City of Portland, Maine - Building or Use Permit Application

| Permit No: 02-0578 | Issue Date: OCT 24 2002 | CBL: 43 G001001 |

Proposed Project Description:
26' ~~rear~~ dormer w/ 2 egress windows
front

RE: 11 Kendall Street – R-3 zone with shoreland overlay – 431-G-001

REVISION:
SITE PLAN
 FOR A PROPOSED EXPANSION
 11 KENDALL STREET PORTLAND, MAINE
 FOR:
RICHARD AND BERNICE JENDRASKO

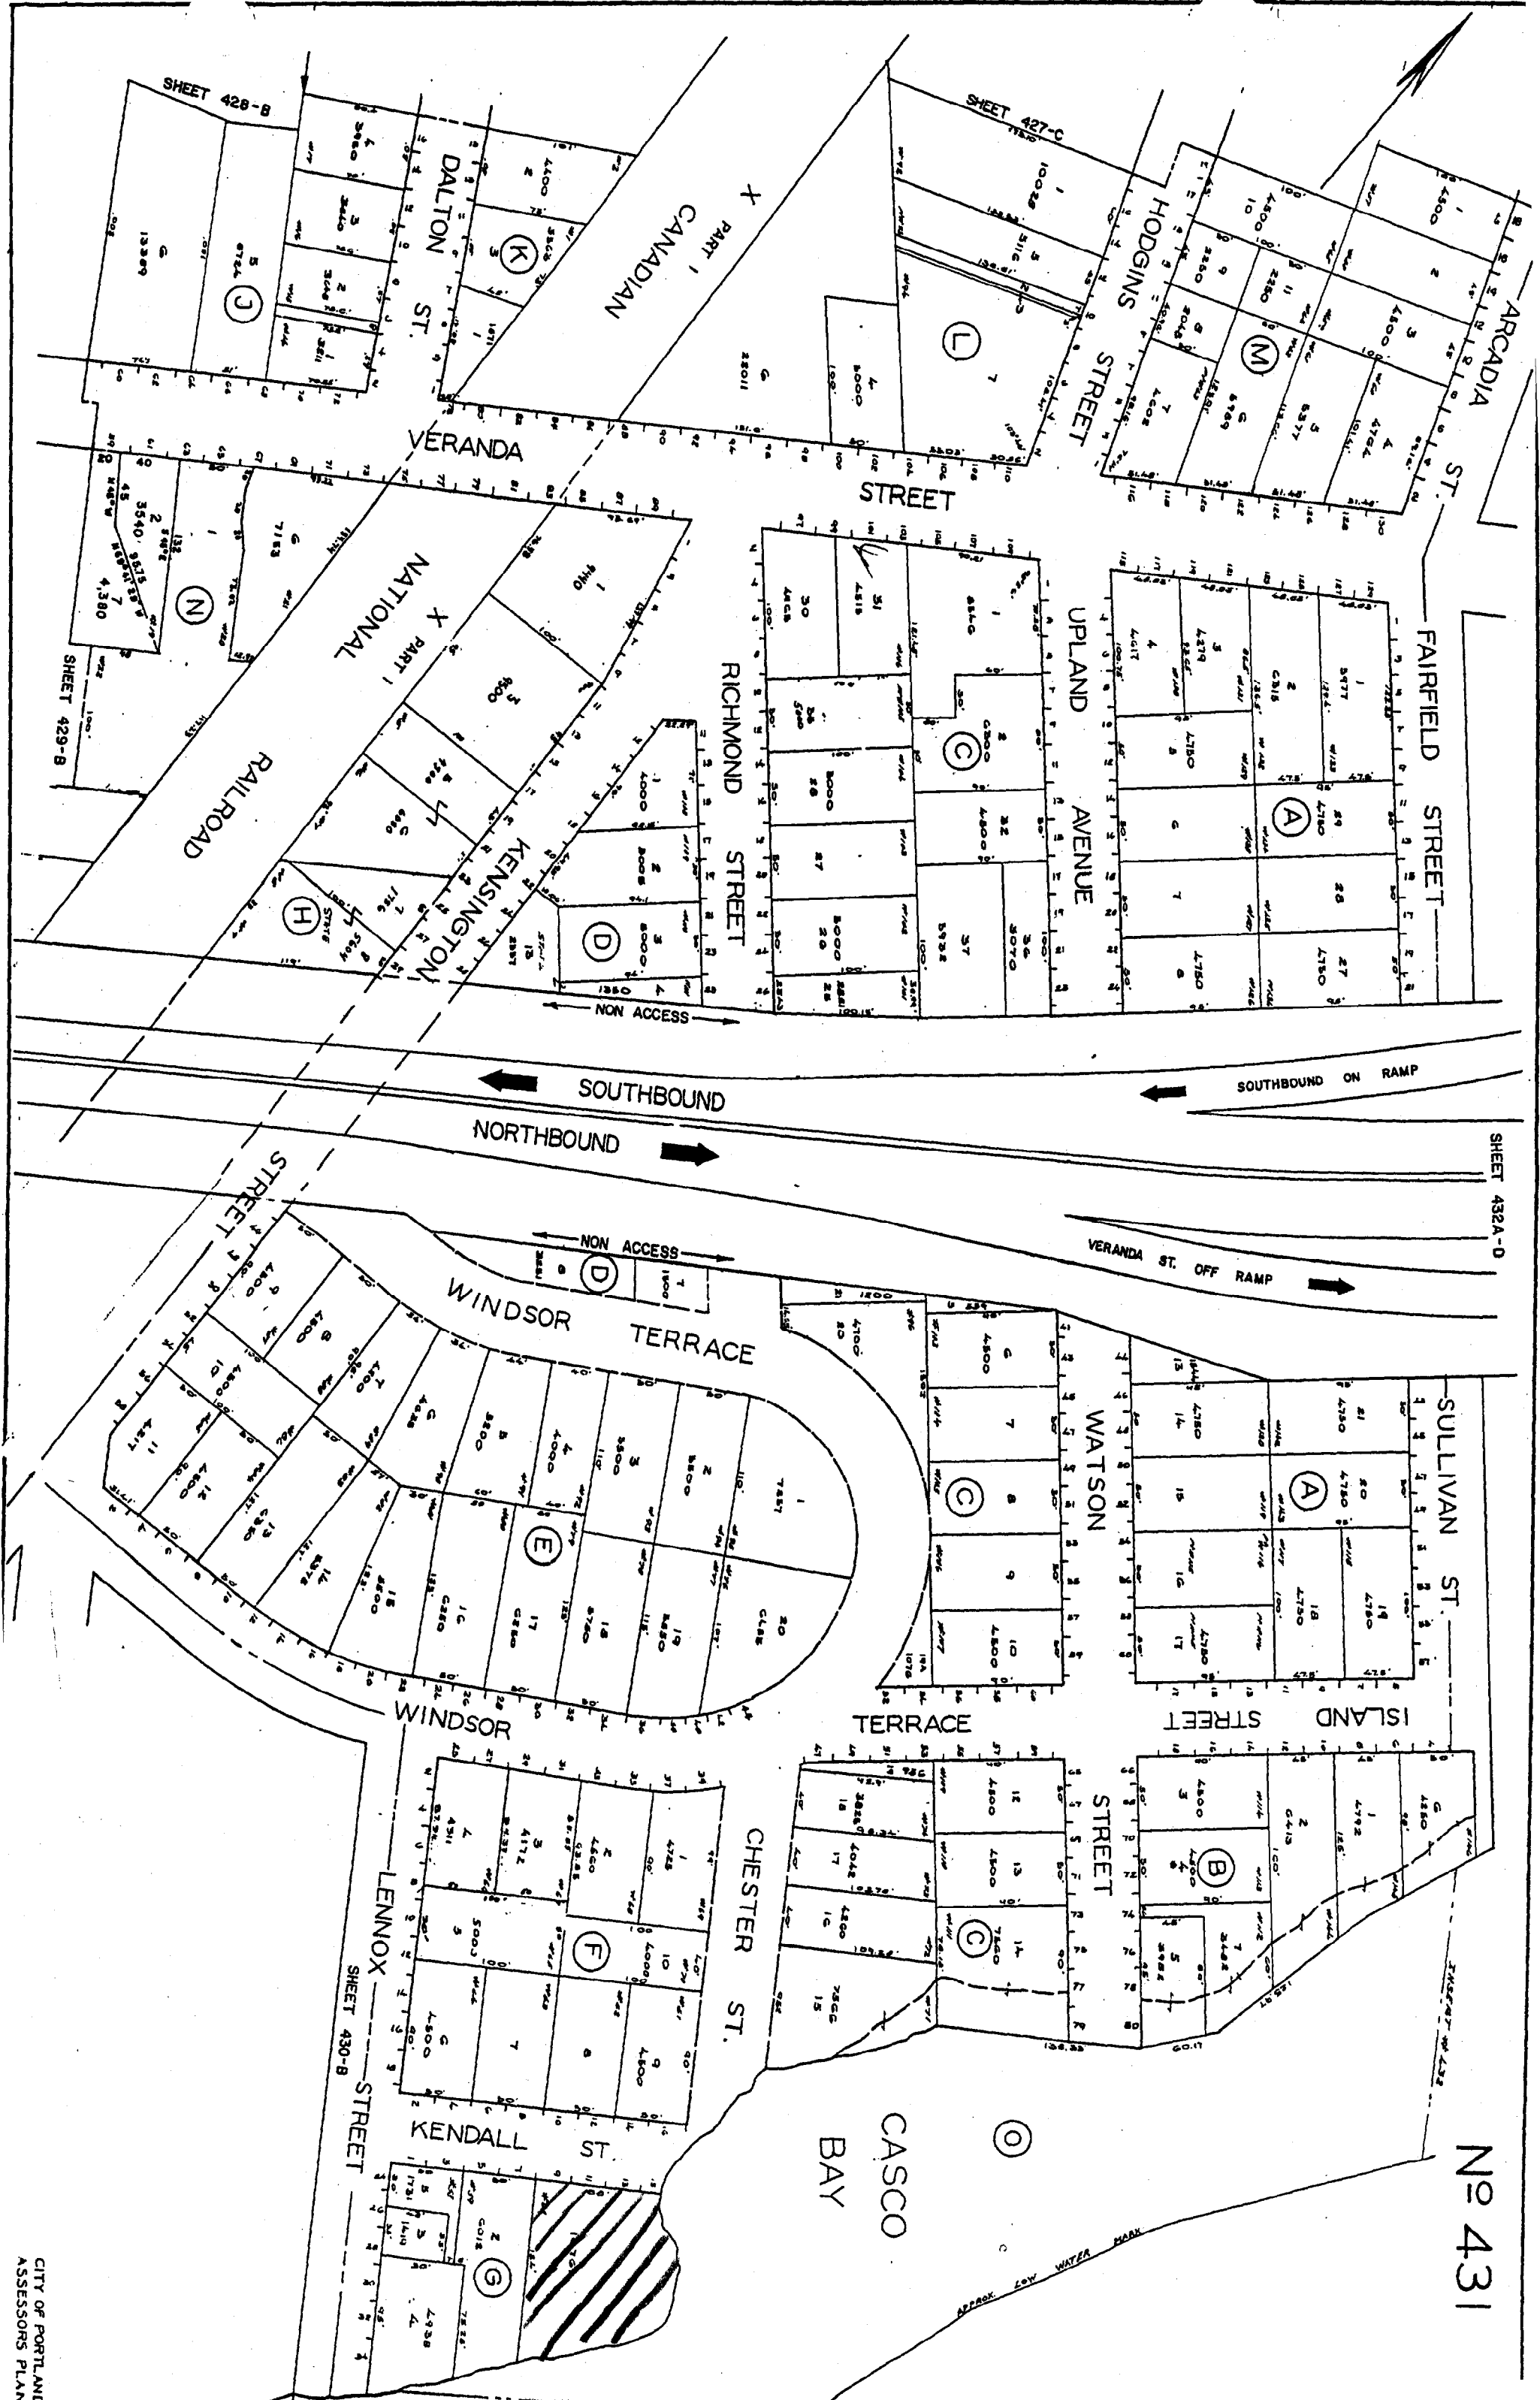
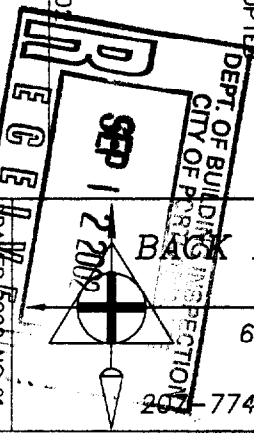
I am in receipt of your survey from Back Bay Boundary, Inc. It is showing that your entire principal house structure is within the 75 foot shoreland restricted area. As I wrote in my previous letter, you may not increase the square footage nor volume more than thirty (30) percent during the lifetime of your structure. I have researched the department's microfiche on this structure and have not found that you have increased this structure since it was built in 1939.

The next step is to establish the existing square footage and volume. Subsequently, the proposed square footage and volume would need to be established. The proposed shall not exceed the existing by more than the 30%.

Your permit has just been given to me for zoning. Because this property is located within a shoreland overlay zone, it is necessary to have a site plan that documents exactly where the 75 foot from the mean high water mark is located on your property. This is necessary in order to figure out compliance with the shoreland zoning regulations.

Within the 75 foot setback from the mean high water mark, you may not increase the square footage nor the volume more than 30% during the lifetime of your structure.

The proposed dormer would therefore stay within the 30% allowable expansion rule.
